Application for a non-material amendment following a grant of planning permission.

PLOT 1 - SLATERS COTTAGE, 3 THE STREET, EAST PRESTON, WEST SUSSEX BN16 1JJ

PLOT 2 - PEARL HOLME, 4 THE STREET, EAST PRESTON, WEST SUSSEX BN16 1JJ

DEMO OF HOUSE & ERECTION OF 2 NO. DWELLINGS (RE-SUBMISSION FOLLOWING EP/15/15/PL)

Rear Elevation (North)

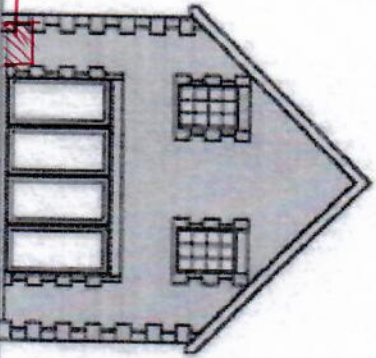
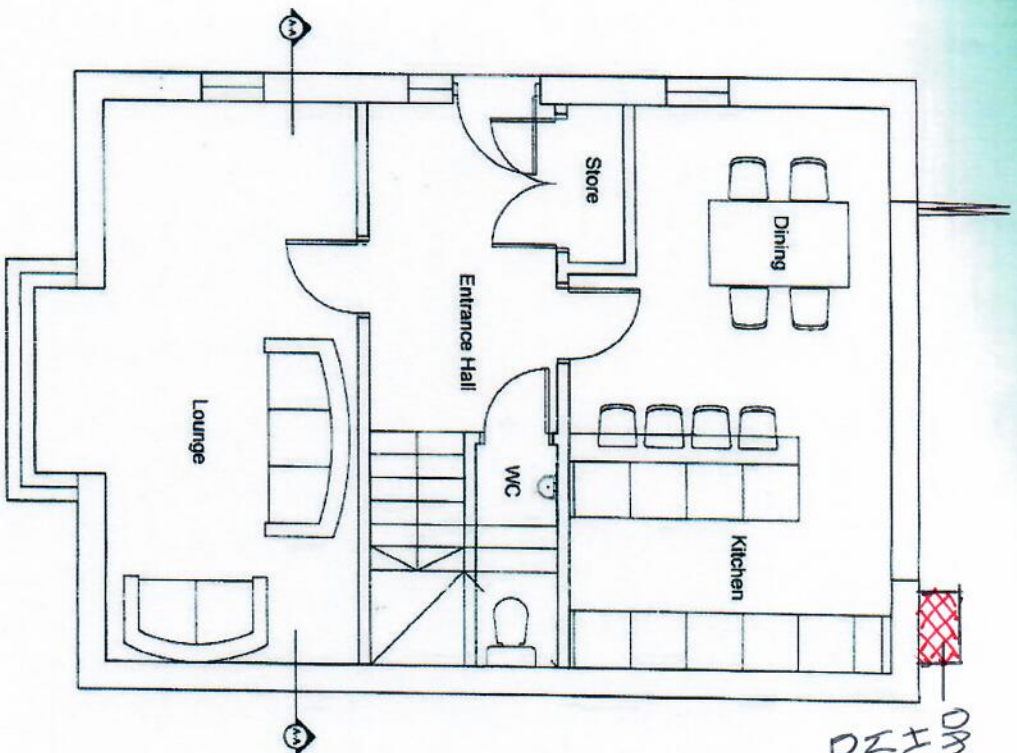
PLOT 1 (SLATERS COTTAGE, 3 THE STREET) - INSTALL A ASHP ATTACHED TO REAR ELEVATION OF NEW HOUSE, NEXT TO NEW FLINT WALL WITH FENCE ABOVE. CANNOT BE SEEN FROM THE HIGHWAY.

Side Elevation (West)

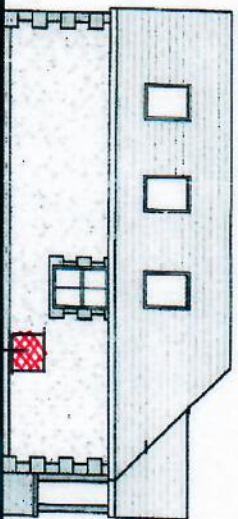
PLOT 2 (PEARL HOLME, 4 THE STREET) - INSTALL A ASHP ATTACHED TO LEFT HAND SIDE ELEVATION OF NEW BUNGALOW, BEHIND SIDE TIMBER GATE. CANNOT BE SEEN FROM THE HIGHWAY.
